KITTITAS COUNTY

MEMORANDUM

TO: All Staff
FROM: Public Works Plan Review Team
DATE: November 10, 2022
SUBJECT: LP-22-00004 Suncadia Ph 1 Div 14

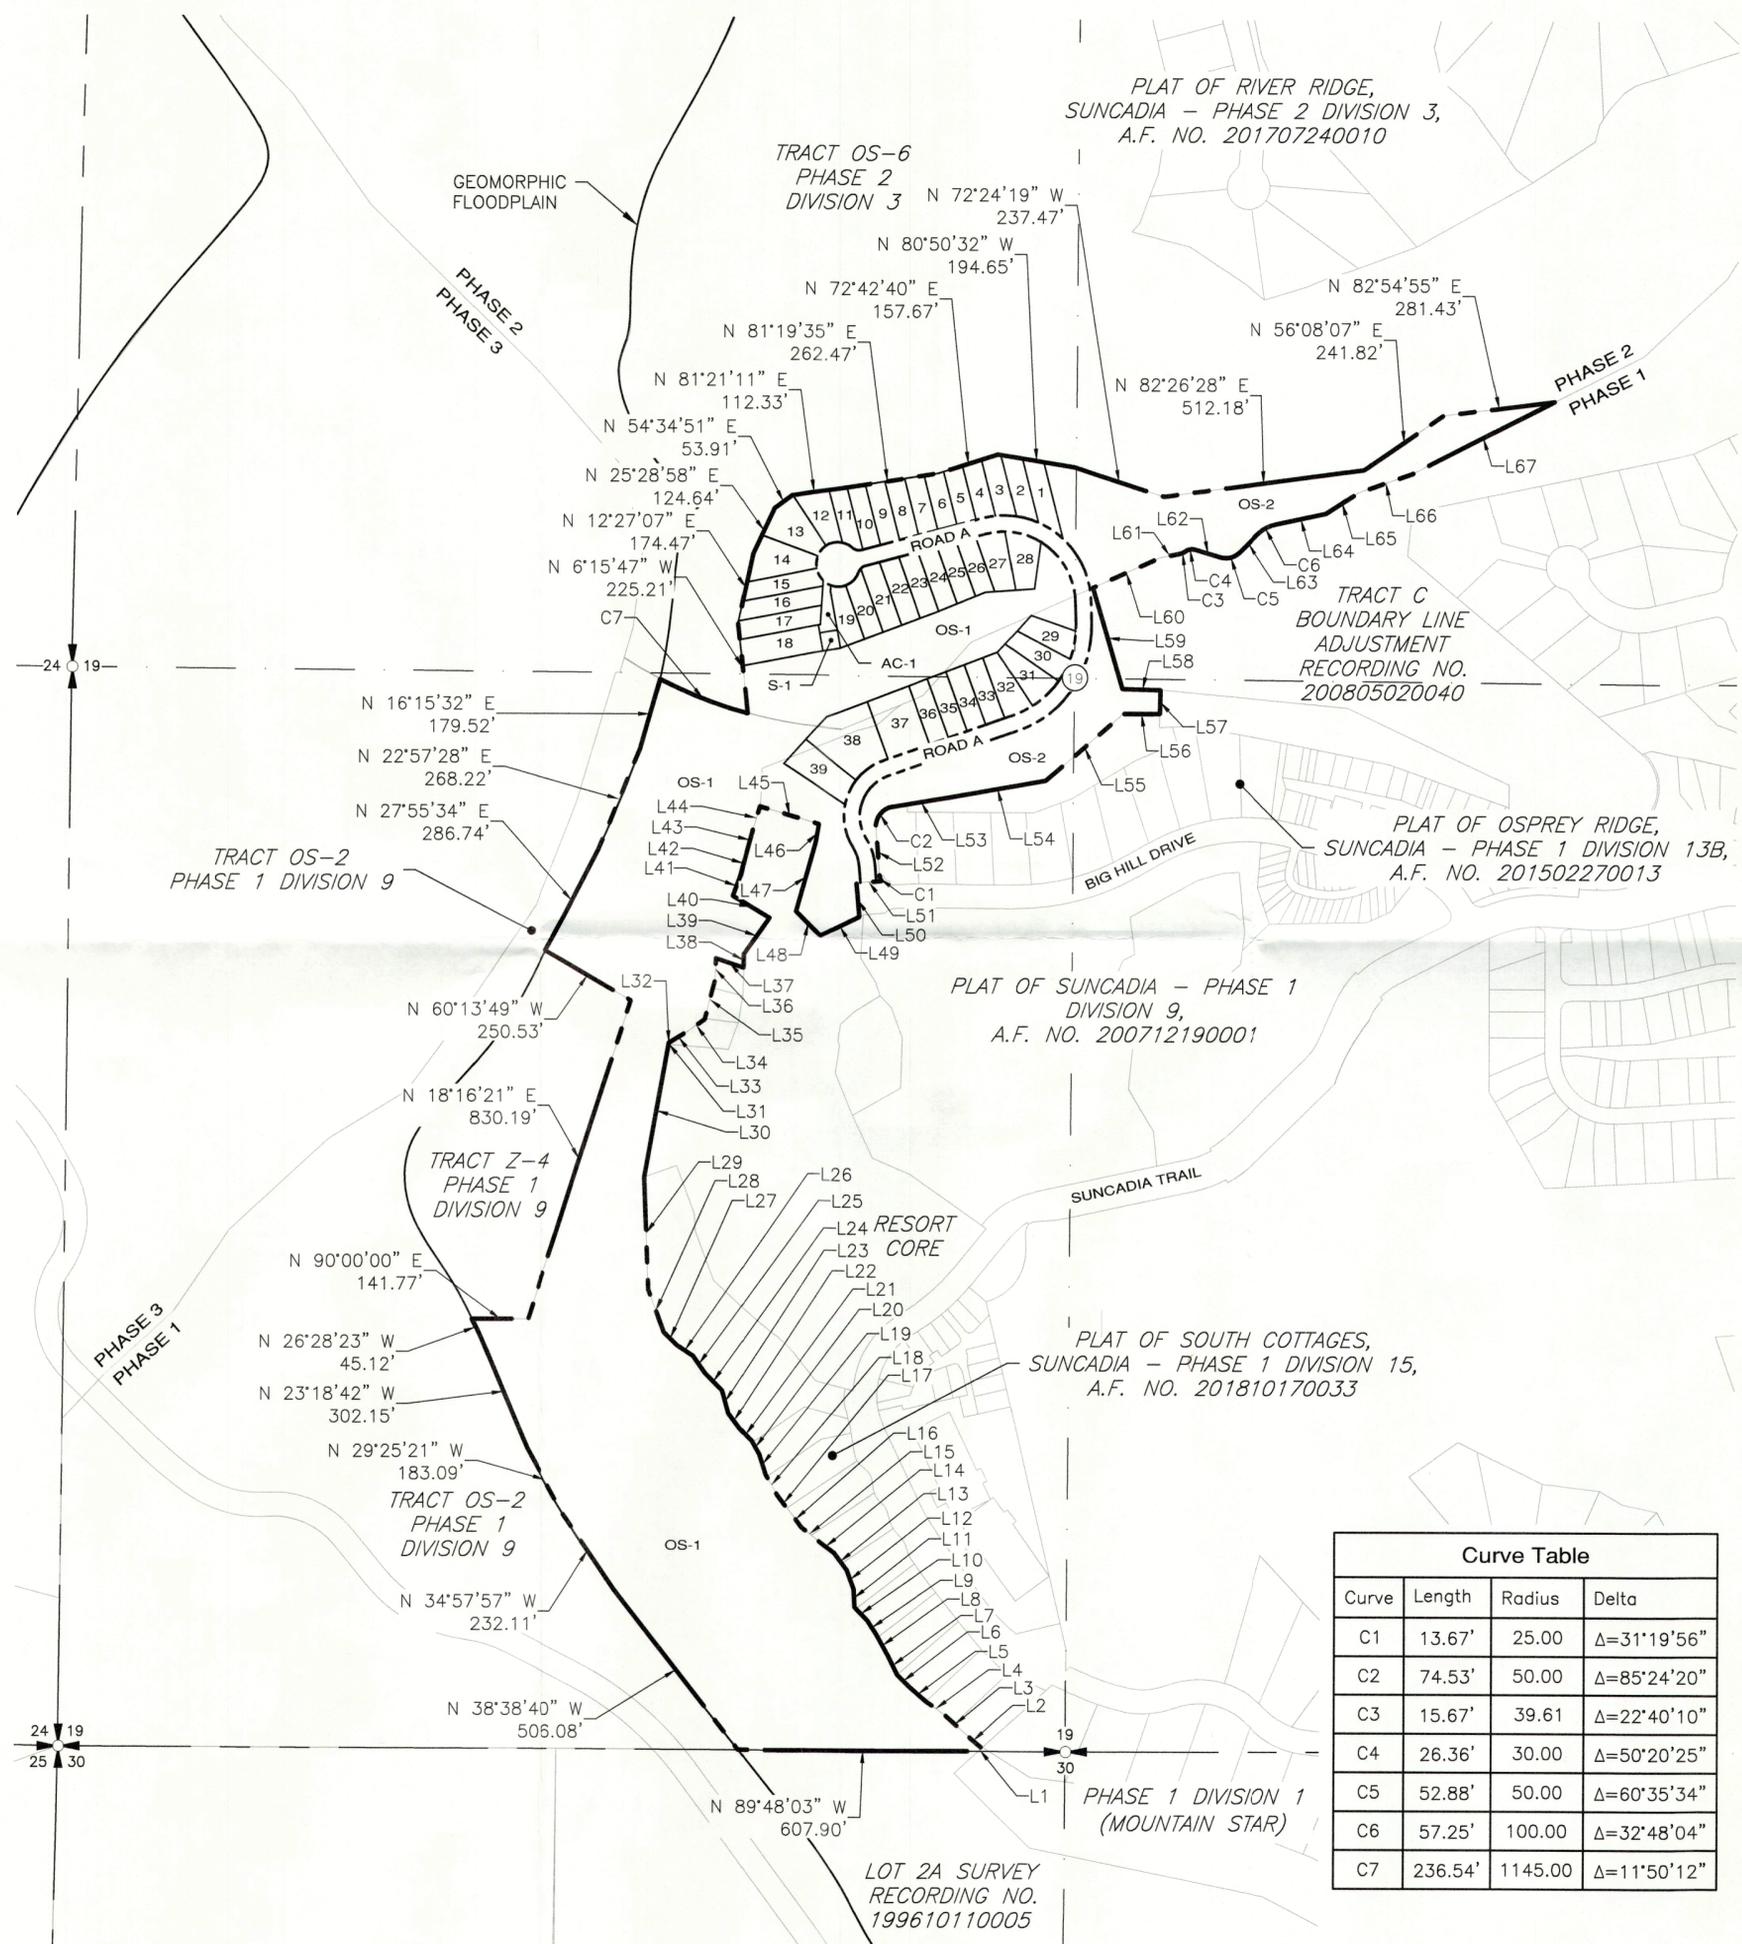
<p style="text-align: center;">EXAMINED AND APPROVED This ____ day of ____, A.D., 20__.</p> <p style="text-align: center;">_____ Kittitas County Engineer</p> <ol style="list-style-type: none"> 4. Please submit engineered plans to Public Works for a Civil Review. This should be completed prior to Final Plat. 5. While Suncadia is in the process of completing the Traffic Monitoring Plan, please submit an update report detailing what monitoring has been completed. This update report will be required for Final Plat. 6. Please provide an inventory of equivalent residential units, or the accounting method utilized in the water system plan, affirming sufficient capacity serving the plat. 7. Please provide an inventory of equivalent residential units, or the accounting method utilized in the general sewer plan, affirming sufficient capacity serving the plat.
<p>SURVEY</p>	<p><u>All pages:</u></p> <ol style="list-style-type: none"> 1. The heading at the top of the pages shall include Name of Subdivision, Section, Township, Range, County and State. <p><u>Sheet 1</u></p> <ol style="list-style-type: none"> 2. Include the additional owner of OS-3, Plat:11-78 in the owner block. Per county GIS this does not match the owner of record shown. 3. Include the Engineer of Record 4. Sewer, stormwater, and road cut/fill slope easements should be contemplated. All easements shown upon referenced conceptual and preliminary documents shall be included on the face of the Plat. 5. Paragraph one of the Legal Description should be revised to read Book 11 of Plats, Page <u>78</u> through 82. <p><u>Sheets 2 and 3</u></p> <ol style="list-style-type: none"> 6. Include ownership, width and surfacing for Big Hill Drive (EX: 60' wide Private R/W - Paved) 7. Please show Road A as a 40' Private ROW 8. Lots OS-1, 37, 38 and 39 all have portions of a prior Open Space parcel (OS-3, Plat 11-78). Development of open Space should be resolved with CDS. <p><u>Sheet 4</u></p> <ol style="list-style-type: none"> 9. Show Cle Elum River.

<p>A portion of parcel 20-15-19054-0003 is located in the FEMA identified special flood hazard area (100-year floodplain). Per KCC 14.08.220, all subdivisions shall show on the face of both the preliminary and final plat, for either short or long plats, the boundary of the 100-year floodplain and floodway.</p> <p>Prior to plat approval the 100-year floodplain boundary must be included on the face of the plat.</p>
<p>WATER MITIGATION/ METERING</p>	<p>No comments</p>
